DECISION DELEGATED TO DEVELOPMENT MANAGER

Application No: H09-0115-20 **Applicant:** Mr & Mrs Gould
Proposal: Rear & side extensions
Location: 22 Fishpond Lane Holbeach Spalding
Terminal Date: 3rd April 2020

North West Elevation

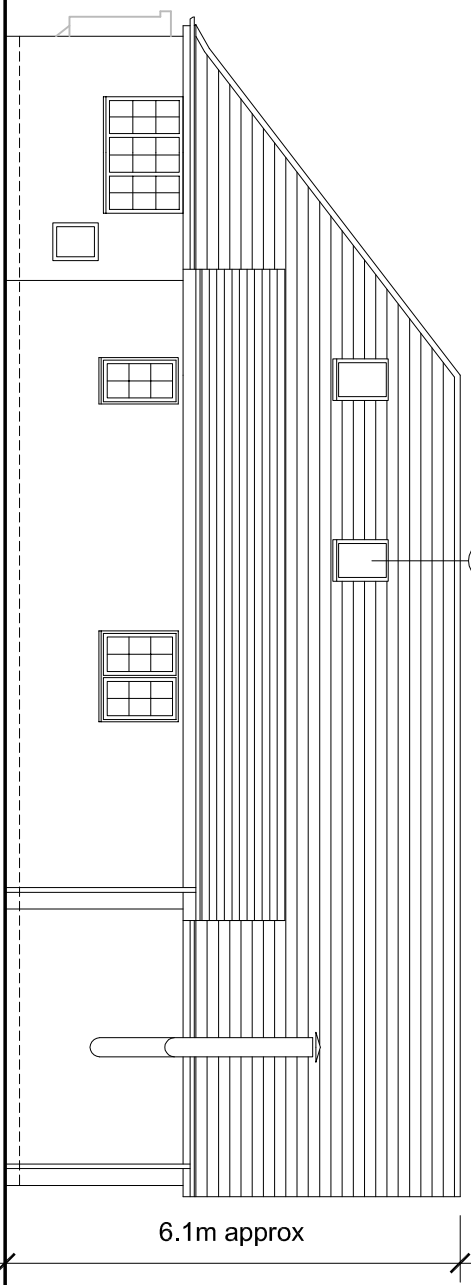
The highest point of the side extension will be 3.70 metres and the eaves as high as those existing in the property. The maximum height of the rear extension will be as much as the ridgeline. Overall, both extensions appear subservient to the host property in terms of scale, mass and bulk.

A flue for kitchen ventilation will be erected on the north-western side of the rear extension. In view of the use and height of the flue, no significant odours might potentially erode the amenity of residents of No. 20.

Ground Floor Plan (1:100)

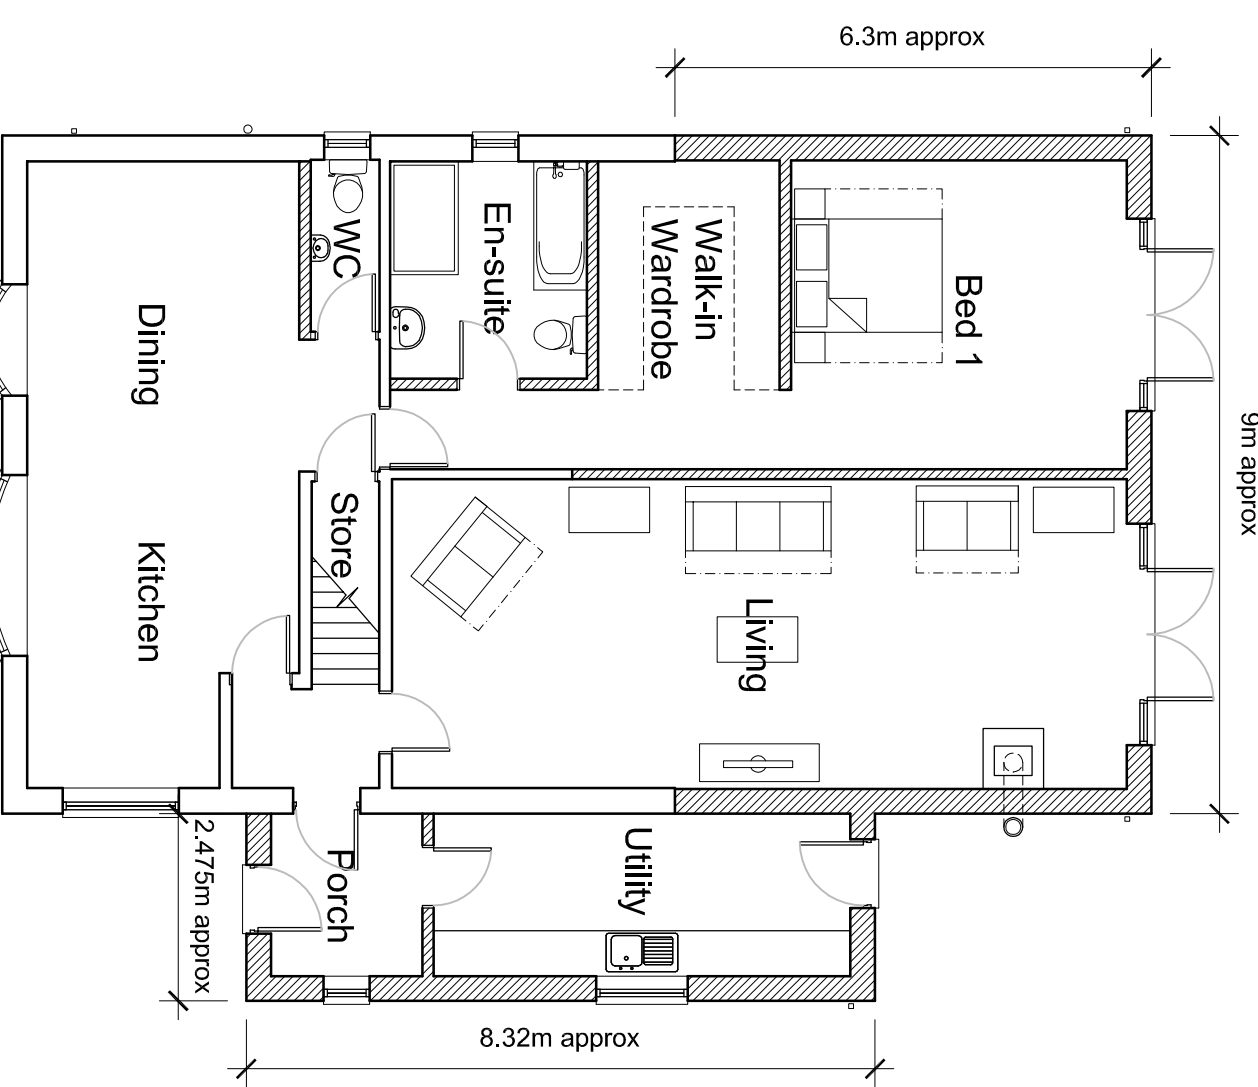
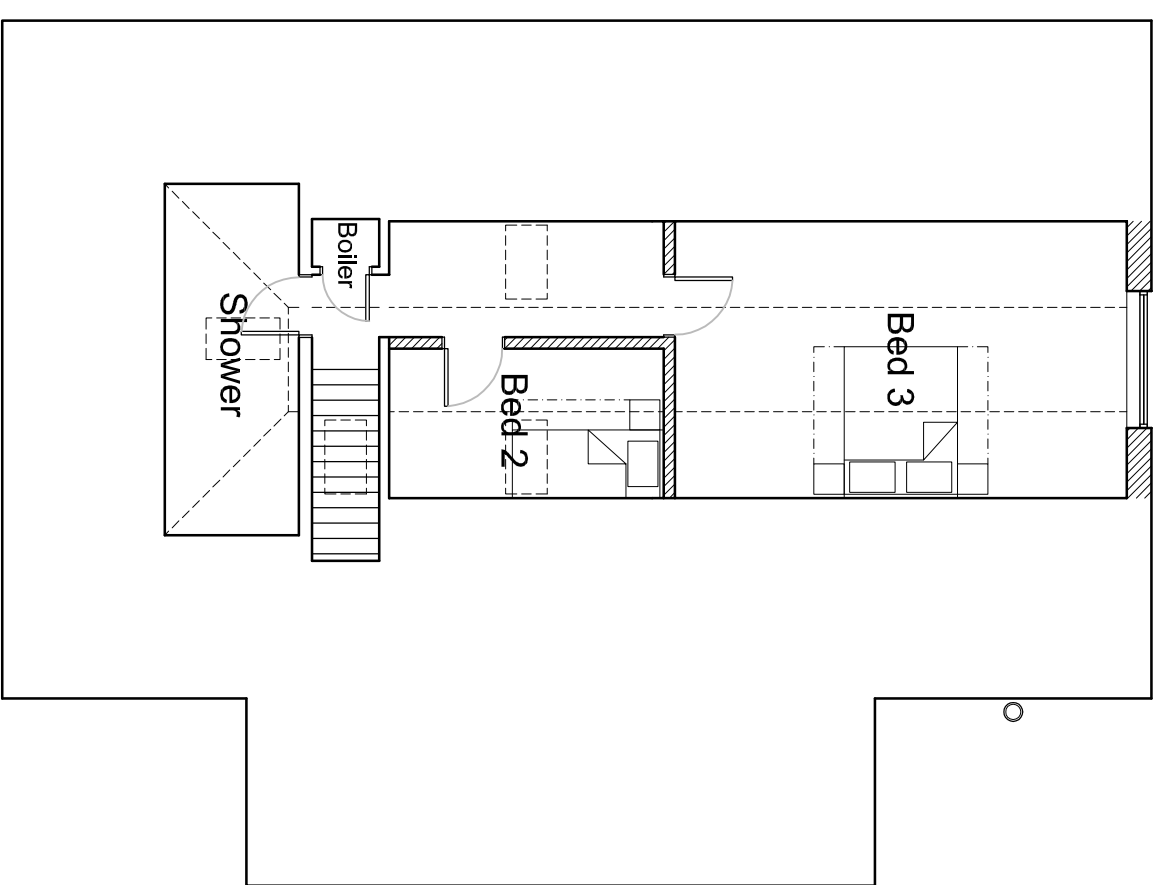
The side extension would approximately protrude 2.47 metres from the north-western wall of the property and will extend 8.32 metres along the elevation. The rear extension will measure 6.3 metres from the original rear wall of the bungalow and will extend its full width.

The existing lean-to on the north-western side elevation will be demolished to accommodate the proposed extension. The internal porch will be reduced and the remainder of the floorspace will be used for a new utility room. The original rear wall will be removed to enlarge both the bedroom and living room on the ground floor. Additional floor space will be gained on the first floor to create a third bedroom. The proposed works for the internal layout are deemed acceptable are in line with the residential use of the building.

The separation distance is about 3.30 metres between the proposed side extension and the north-western boundary adjoining the curtilage of No. 20. In account of its single-storey nature, this extension will not appear overbearing to the residents of No. 20.

The rear extension will be set back nearly 5.80 metres from the boundary abutting No. 20 to the north-west. At such distance, the bulk of the extension is not considered to be detrimental to the extent that it should be refused in this respect. One metre separation will be provided with the boundary adjoining No. 24. The bulk of the rear protrusion will not overshadow the single-storey rear element behind the south-eastern fence taking into account the path of the sun.

Roof Plan (1:100)

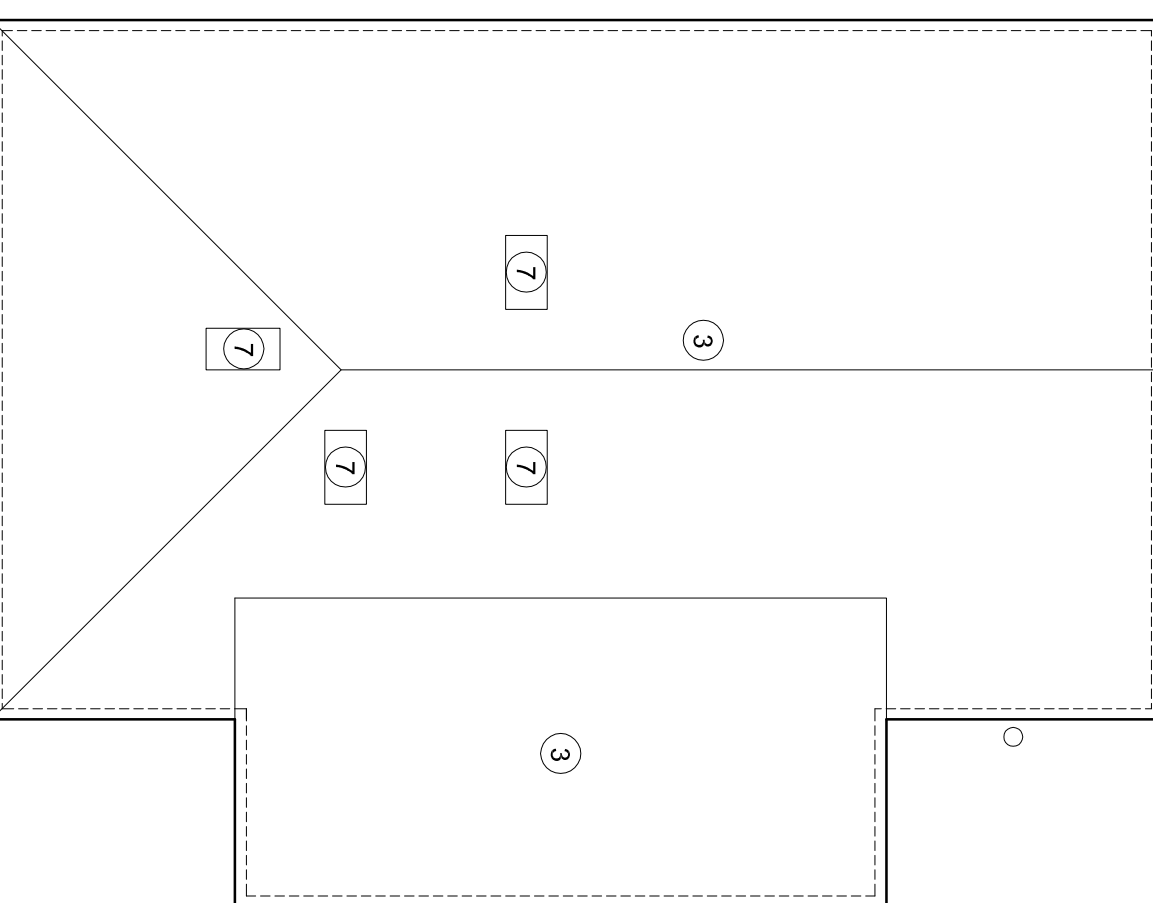
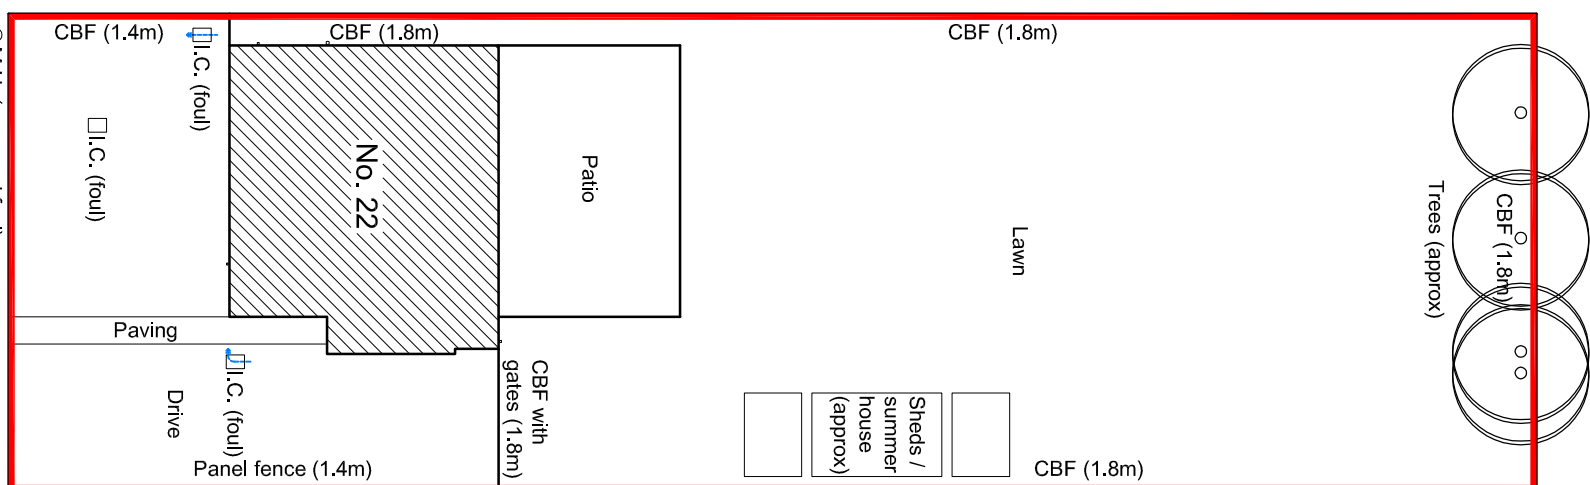
There will be an additional roof light installed on the north-western roof slope. The opposing elevation has also a hip roof slope but with no similar openings. Thus, no overlooking is anticipated through the intended roof light.
